Our ref: DOC20/581552-8

### **Response to Submission comments for Lindfield Learning Village SSD 8114**

Thank you for your referral dated 17 July 2020 inviting comments from the Heritage Council of NSW on the Response to Submissions document for the above State Significant Development (SSD). It is noted that Heritage NSW is providing comments on Urbis responses to the Heritage Council Submission and Heritage Council Recommended Conditions of Consent dated 13 December 2019 in Appendix D, *Lindfield Learning Village Response to Submissions - Built Heritage*, prepared by Urbis Pty Ltd, dated 27 May 2020.

TITLE STAGE 2 - GA PLAN -
LEVEL 4 - ZONE J

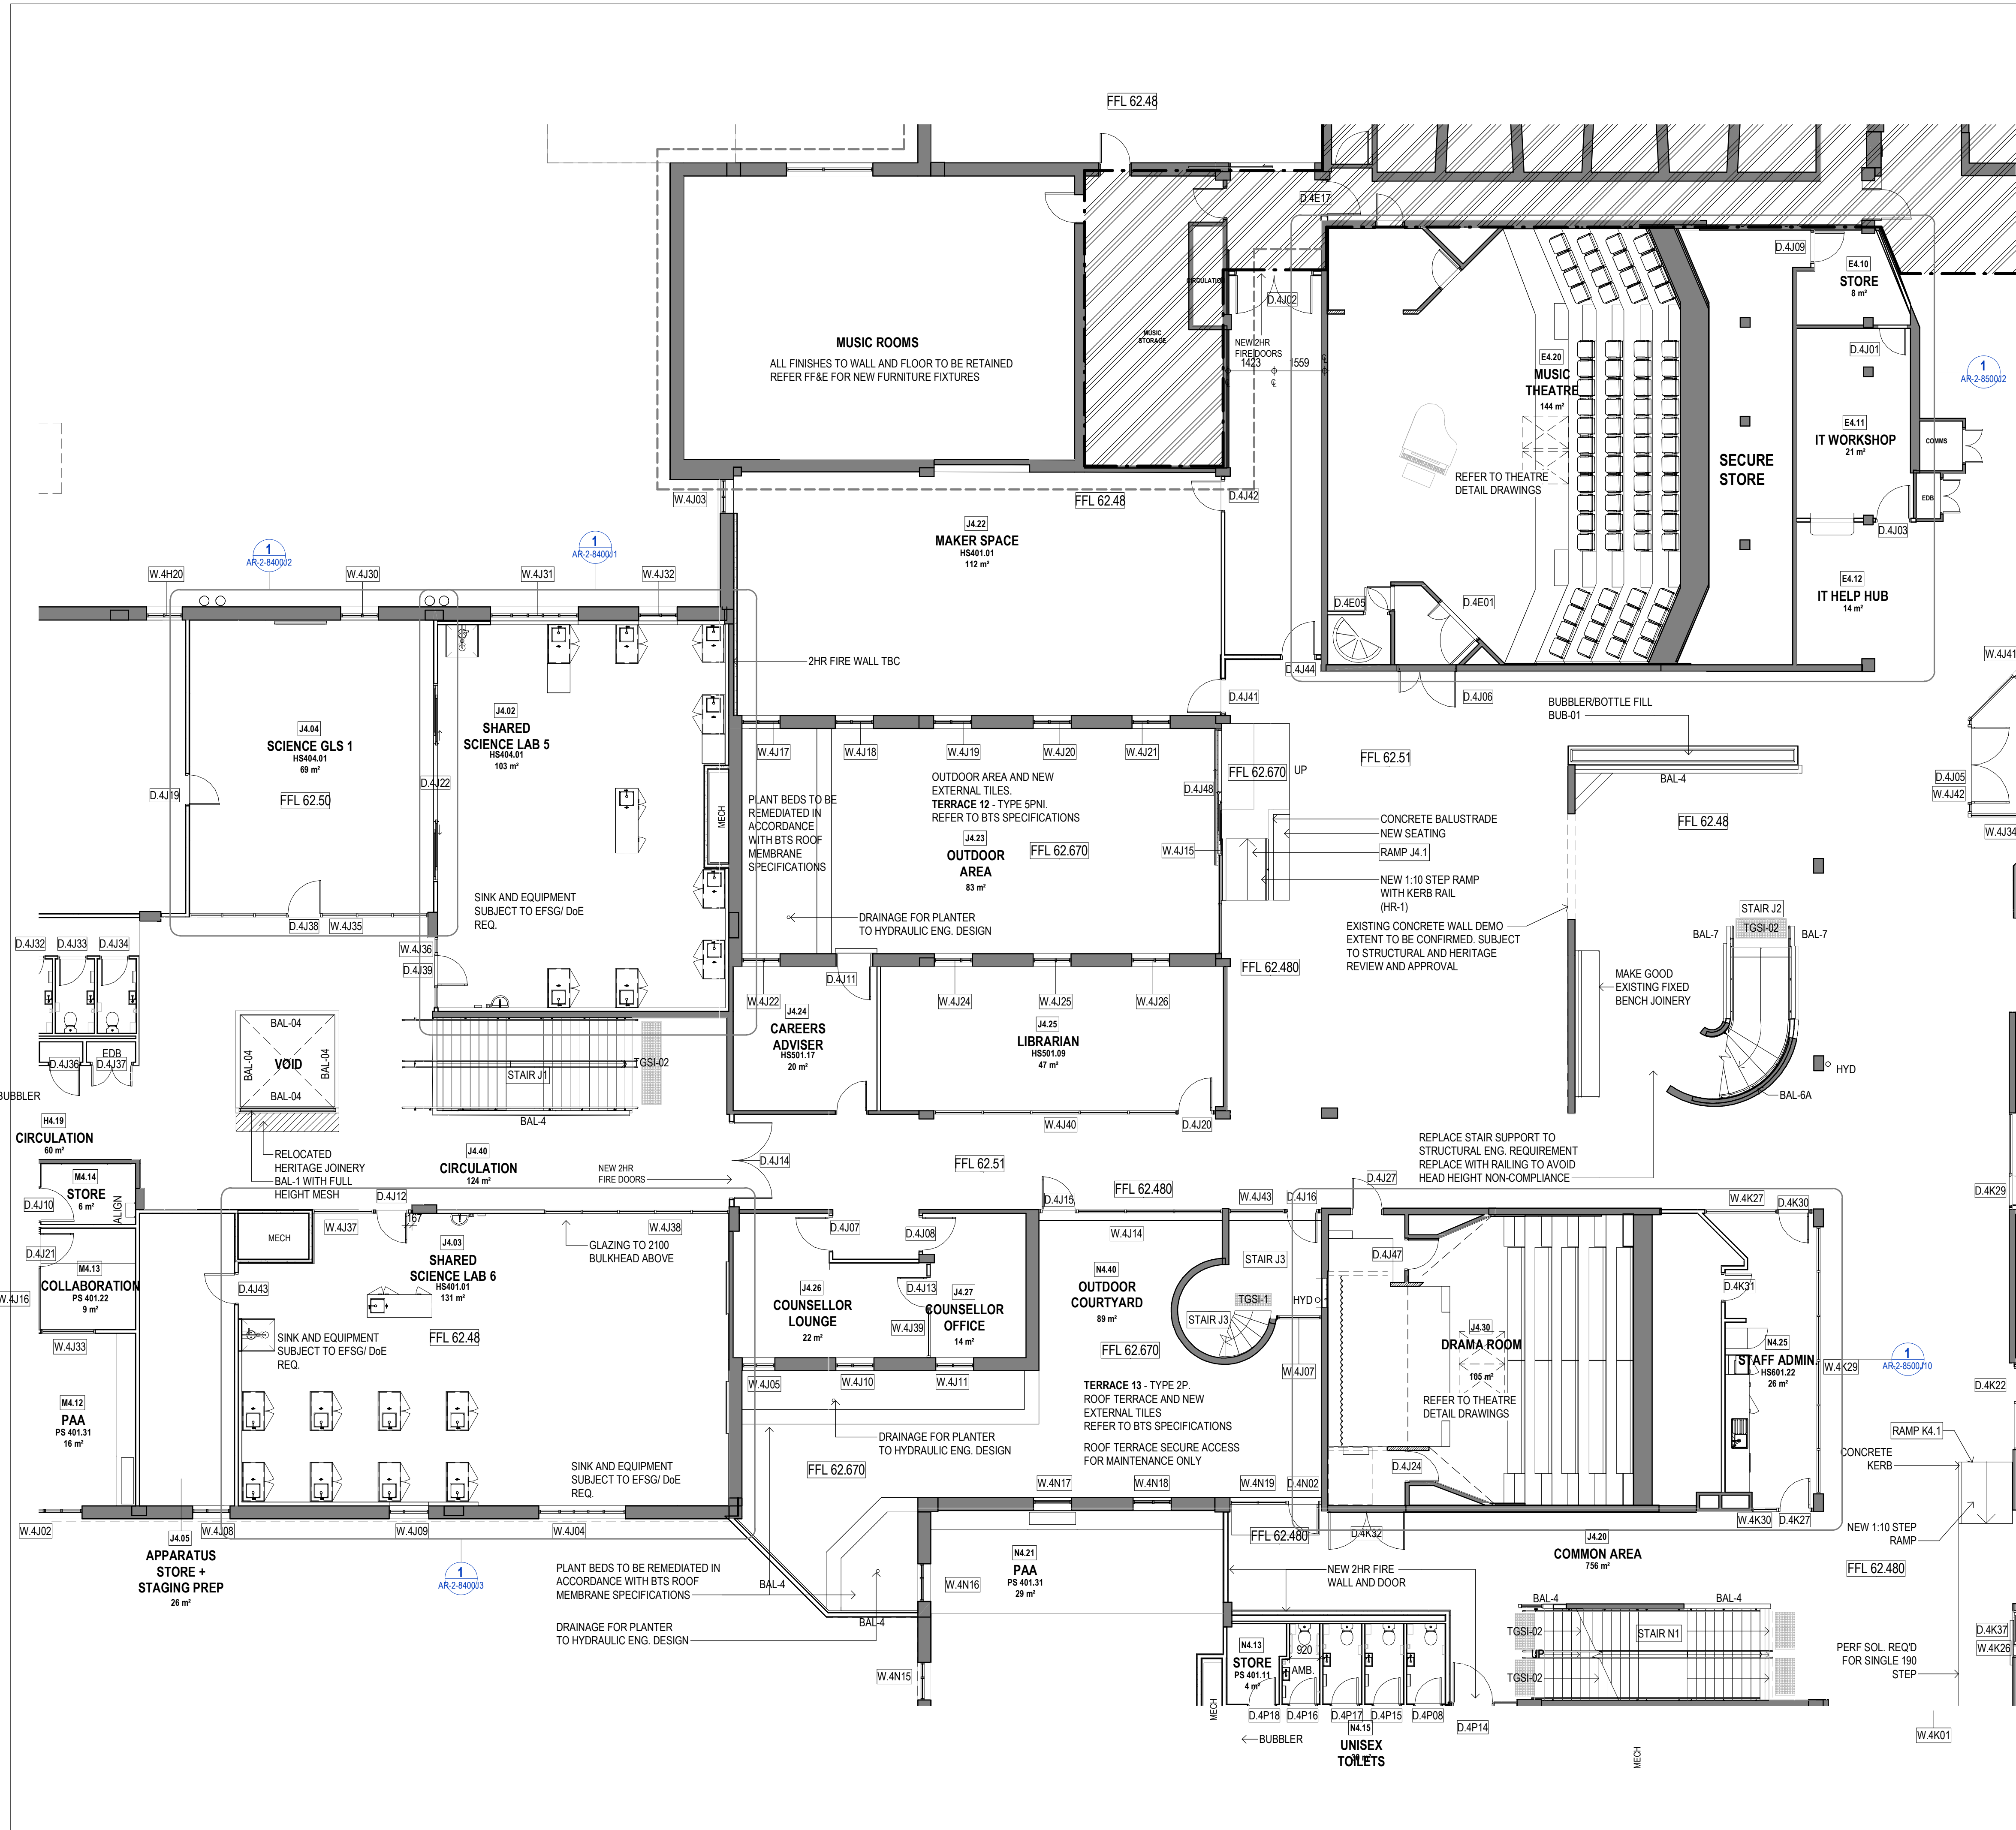
The proposed removal of two portions of concrete wall for increased light penetration will require the removal of a substantial amount of original fabric, identified as of high significance. The removal of a substantial area of the existing concrete wall adjacent to the spiral stair will have an irreversible physical and visual impact on the significance of the item.

**HNSW comment:** The removal of two portions of concrete wall for increased light penetration will require the removal of a substantial amount of original fabric, identified in the CMP as of high significance.

This should be avoided and the Heritage Council recommended condition of consent from the correspondence dated 13 December 2019 (above) be included requiring that an alternative light source is designed

It is recommended that a condition of consent be included requiring that an alternative light source is designed to ensure significant fabric and views are preserved intact.
